## Jeanie Bourke - Re: CWS Studio Restrooms at O'Maine Studios

**From:** Jeanie Bourke  
**To:** Rory Strunk  
**Date:** 10/8/2015 1:16 PM  
**Subject:** Re: CWS Studio Restrooms at O'Maine Studios  
**CC:** Douglas Morin

As I understand your comments, the new M & F bathrooms will remain in the same location, including dimensions and details as drawn on the approved plans from the City of Portland, see attached set.

A3 ENLARGED PLAN @ TOILET ROOMS AND RAMP
REFERENCED FROM: A5/LS1.01 SCALE: 1/4" = 1'-0"

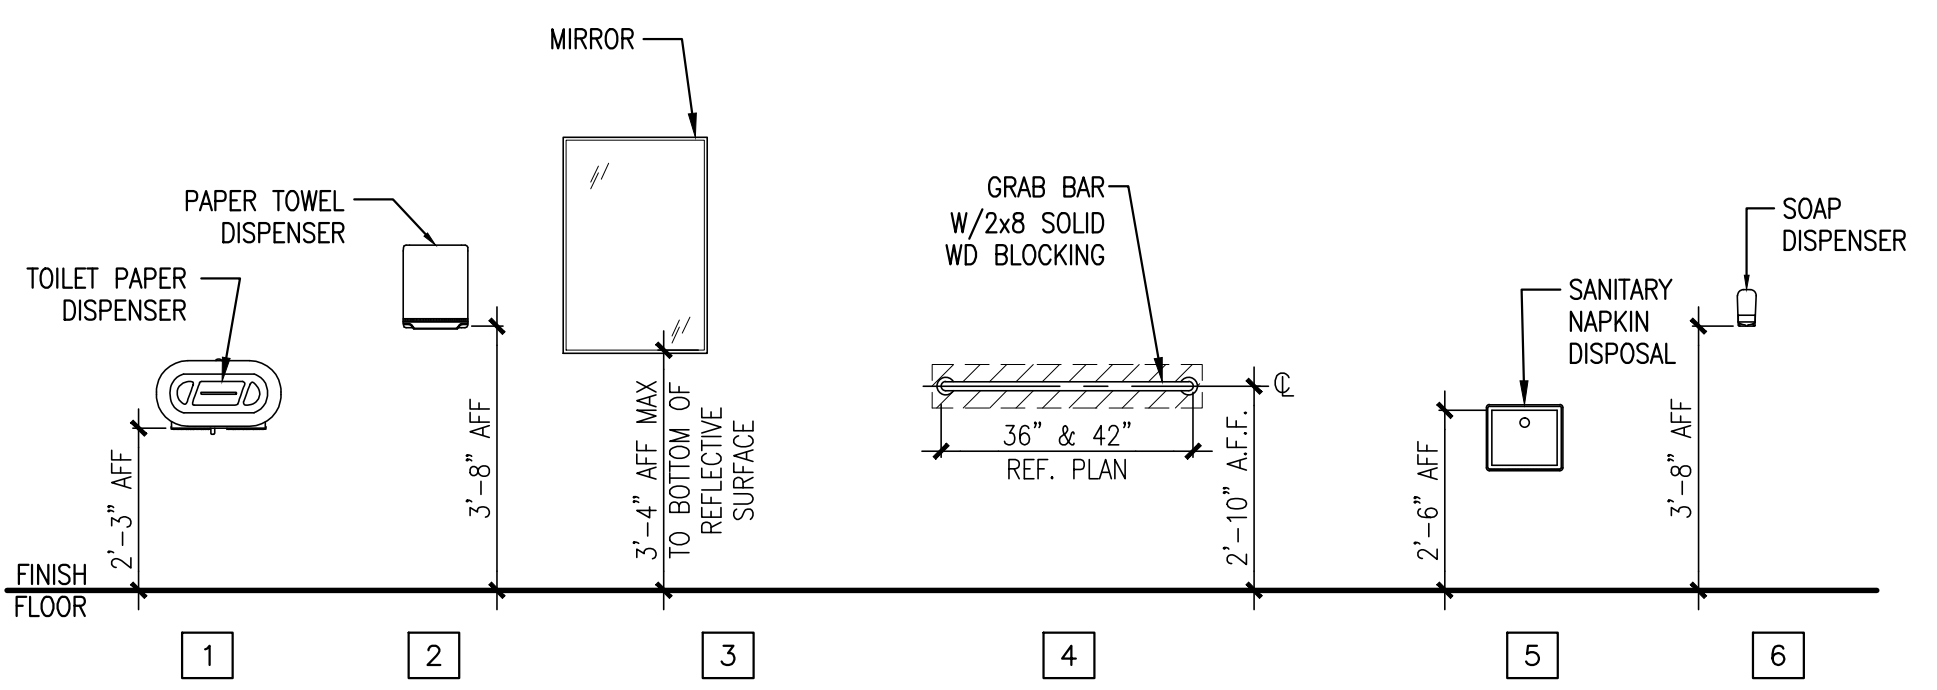
This confirms that the only revision of these plans is the elimination of the ramp and platform, as the bathrooms are now built on slab elevation. This email will act as documentation of this change, no amendment is required. I will file this with the approved plans.

The good news is that we only have one change in the entire set up of the rest rooms. The only change is the removal of the ramp as result of being able to do floor level construction with all walls, doors and fixture placements remain as indicated in the plan attached.

Question ... Given the minor change can we do a written amendment indicating that "no ramp was needed as result of floor level construction" instead of Guy creating a revised drawing? Guy does not have time right now to make the changes to the plan for a couple of weeks and it would also save us about \$300.00.
